CITY OF ALBUQUERQUE

February 19, 2021

Re: Jiffy Lube
9386 Coors Blvd NW
Traffic Circulation Layout
Engineer's/Architect's Stamp 2-19-21 (C13D024)

1 SITE PLAN
1"=20'

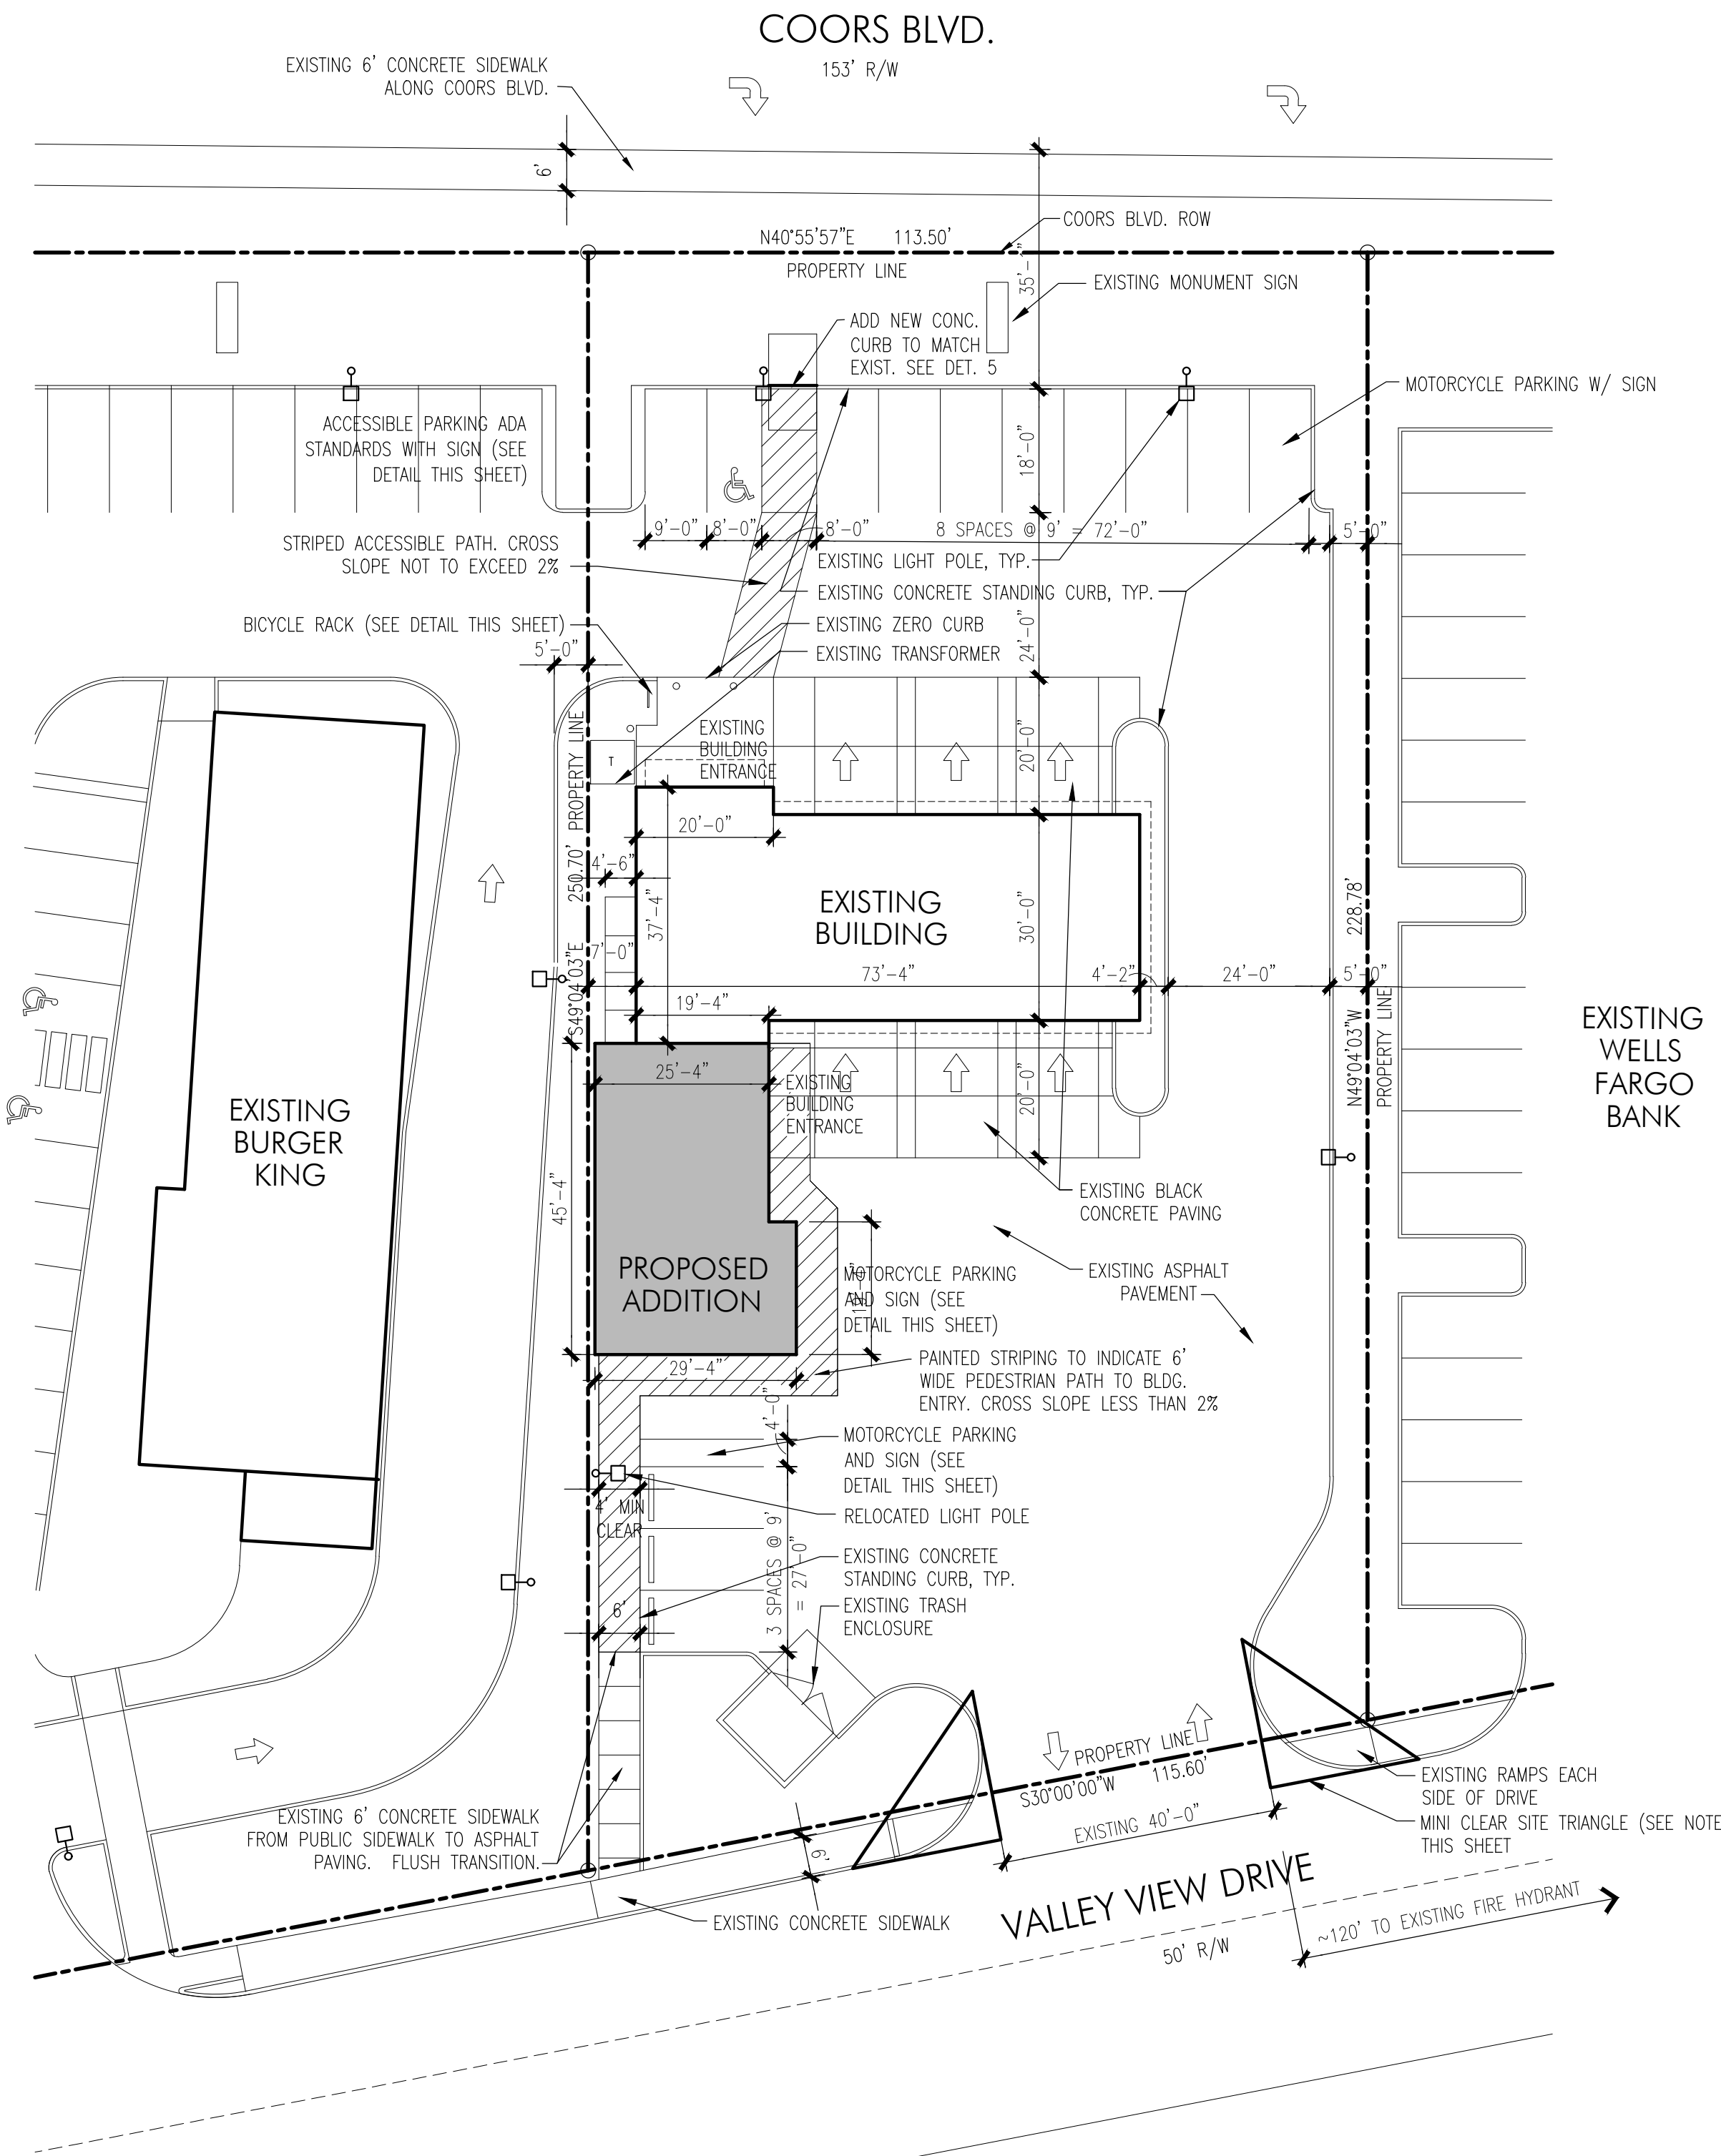
1. Please clarify property lines. Maps indicate property lines do not go into sidewalk off Coors.
2. Pouring a connection from existing sidewalk off Coors to existing ADA ramp requires DOT approval.
3. ADA ramps need to be updated to current standards. Does existing ADA ramp meet the maximum running slope of 8% and maximum cross slope of 2%? Contours show a drop from top to the bottom of the ramp.
